App No: A/55/21/DOC
Address: Land South Of Mayflower Way Angmering BN16 4AY
Description
of Works: Approval of details reserved under condition imposed under A/219/17/PL relating to
Conditions 3 - contamination 11- Surface Drainage Water 13- SUDS Management 17
-Hedgerows 18 - Badgers

PROJECT TITLE: MayflowerWay Angmering	
PROJECT NUMBER: DD486	PLOT DATE: 03.02.21
DRAWING SCALE: 1:200	APPROVED BY: PD
PAPER SIZE: A1	DRAWN BY: JT
DRAWING TITLE: Existing Hedge Retention and Enhancement Plan - Condition 17

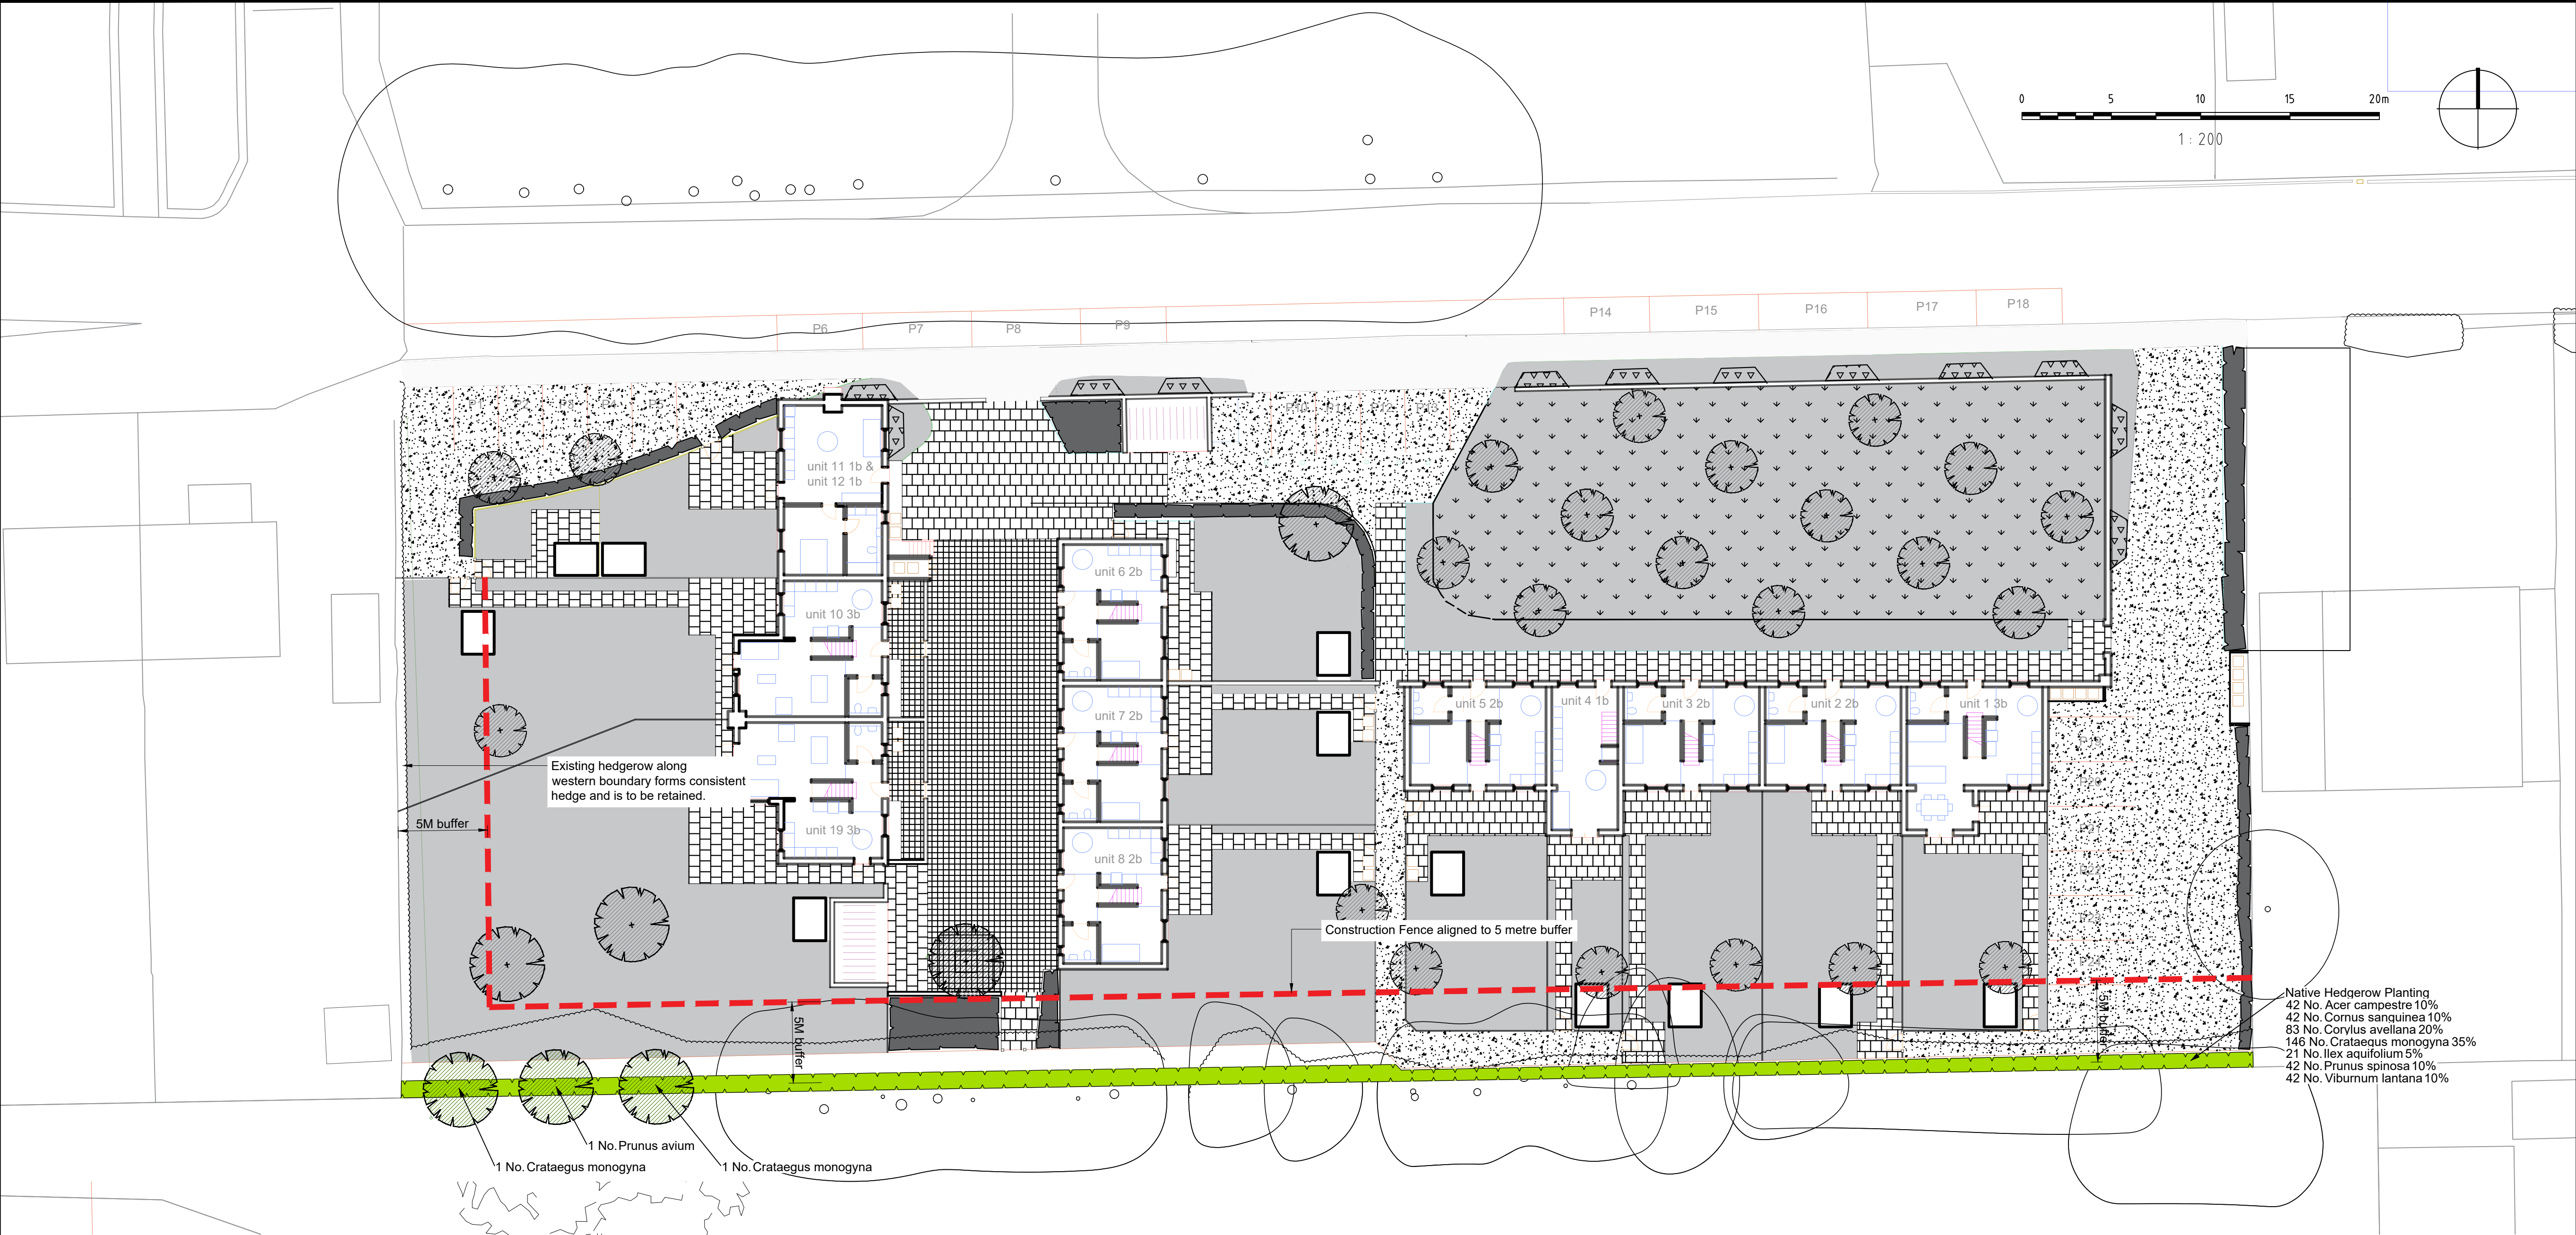
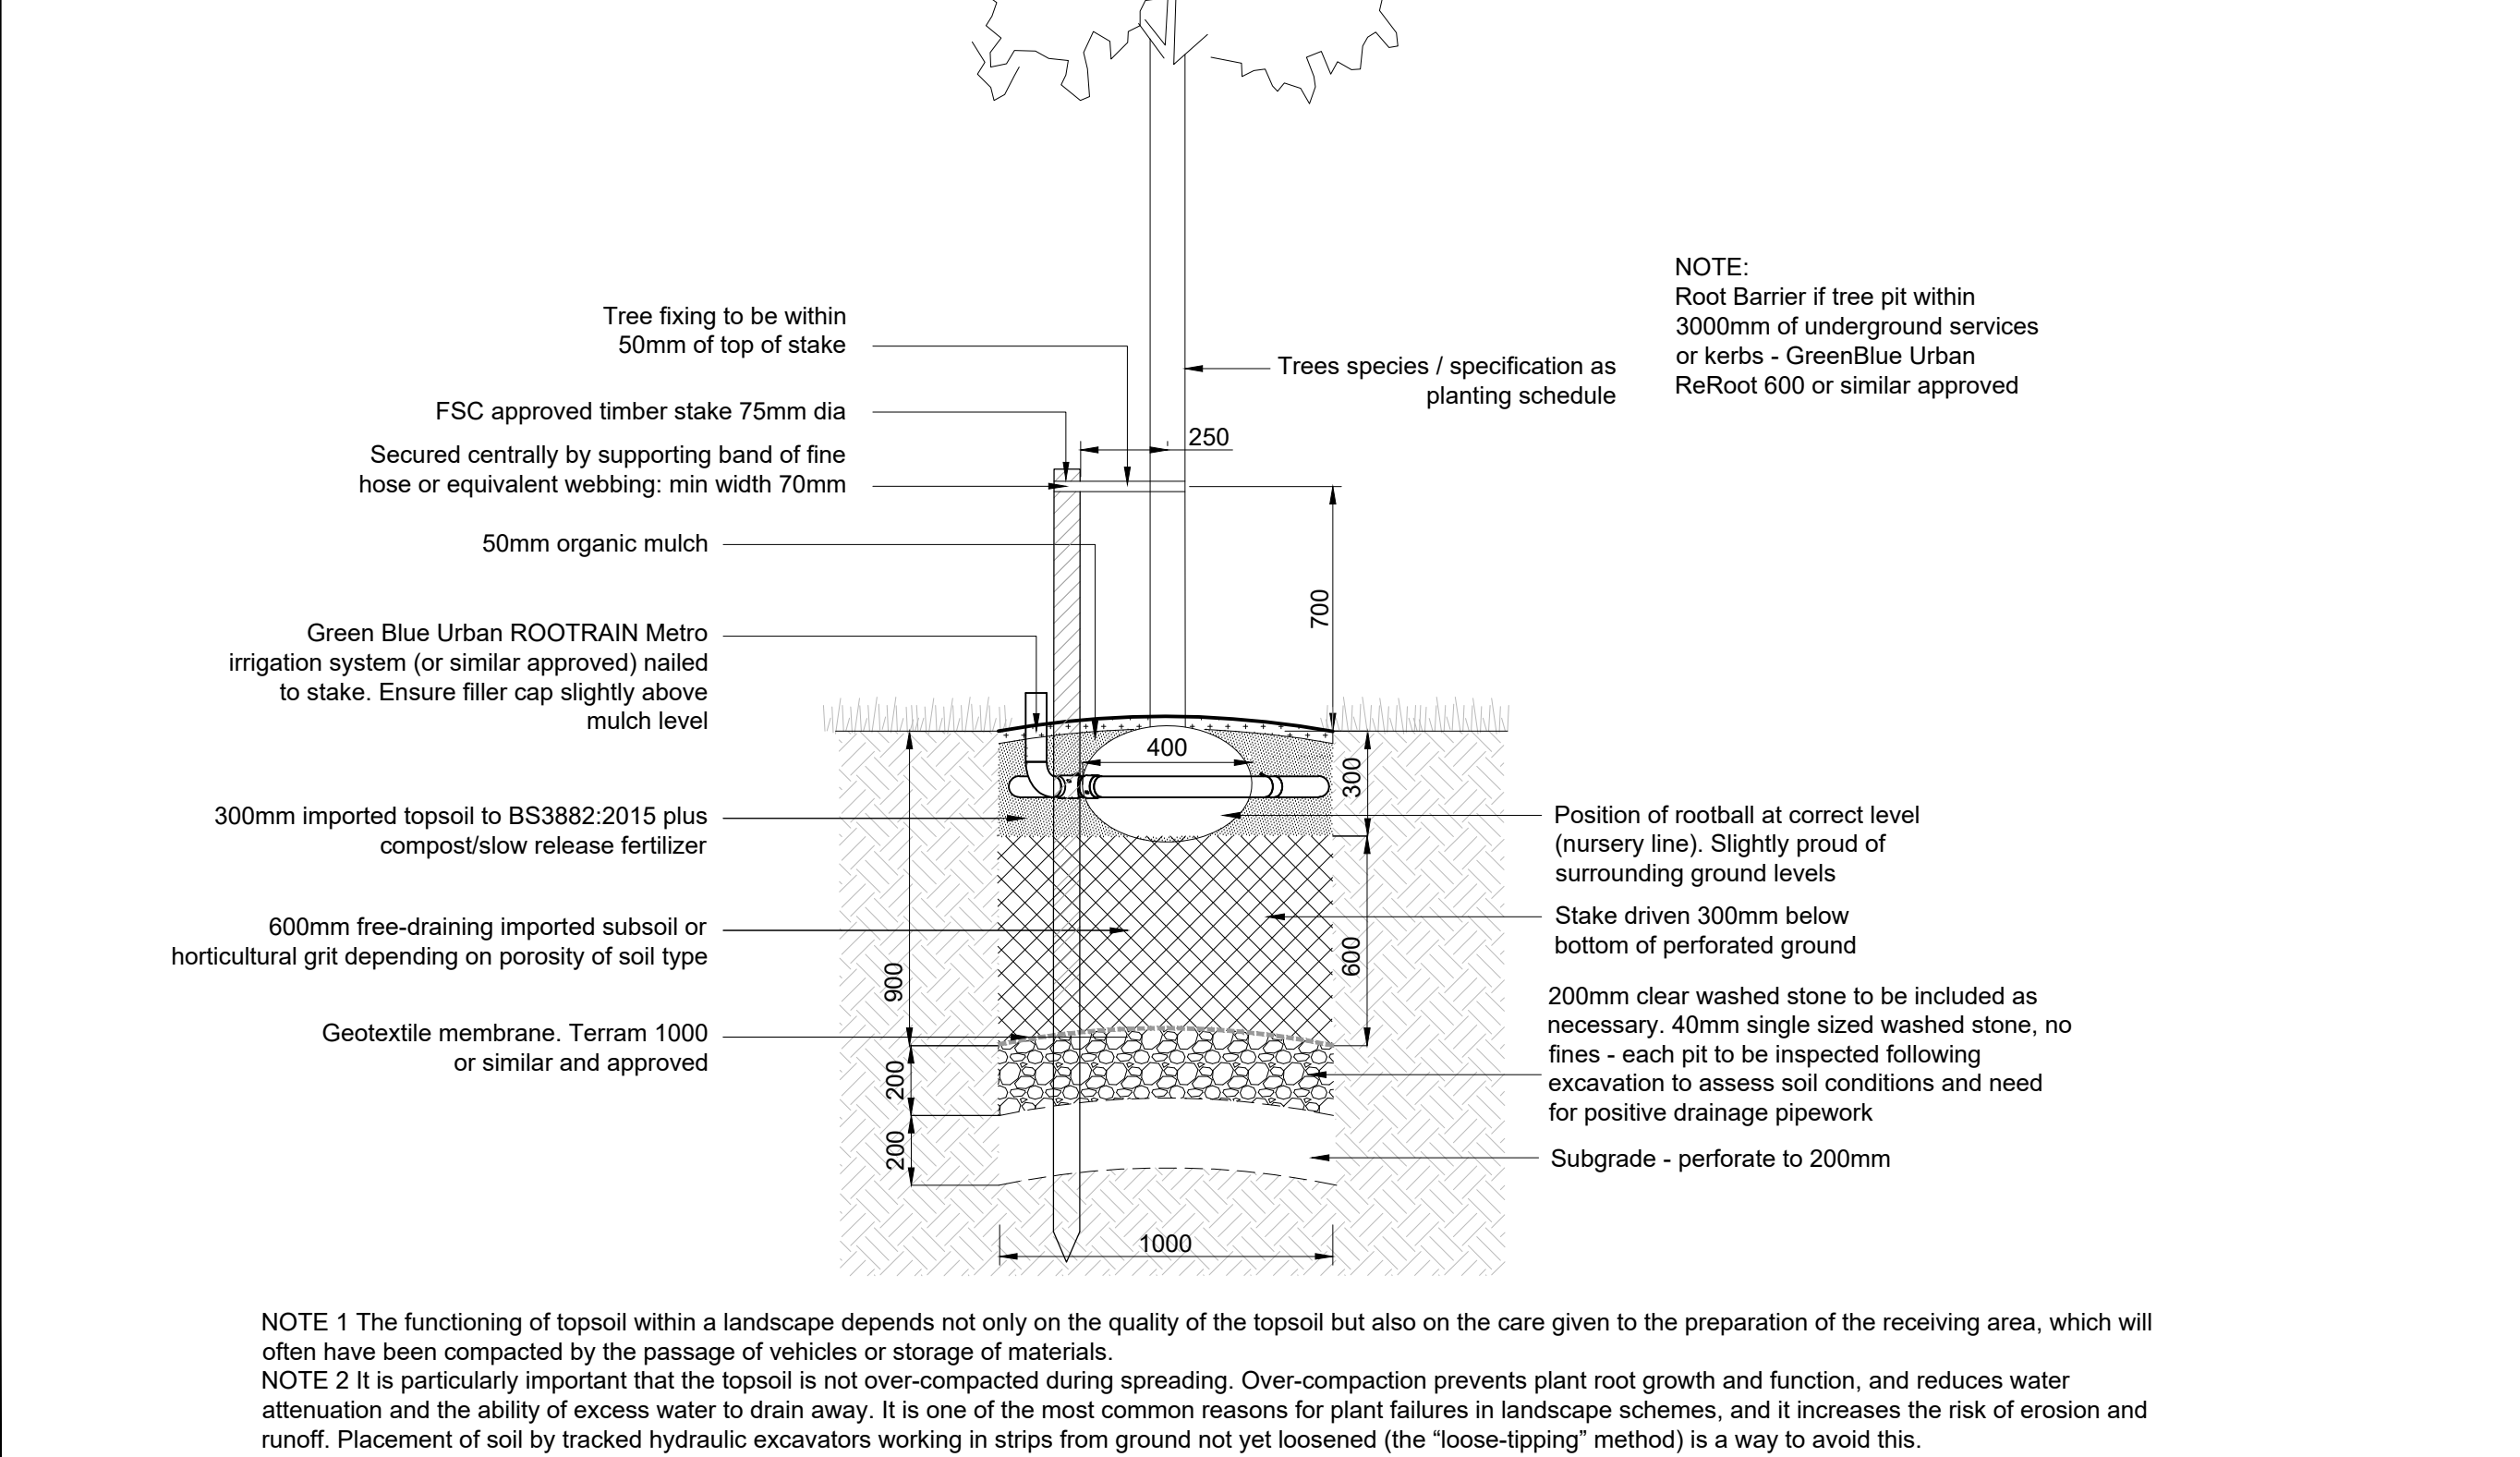
Condition 17- Hedgerows:

Following submission of the hedge retention plan we are satisfied that this is suitable and no further information is required relating to this.
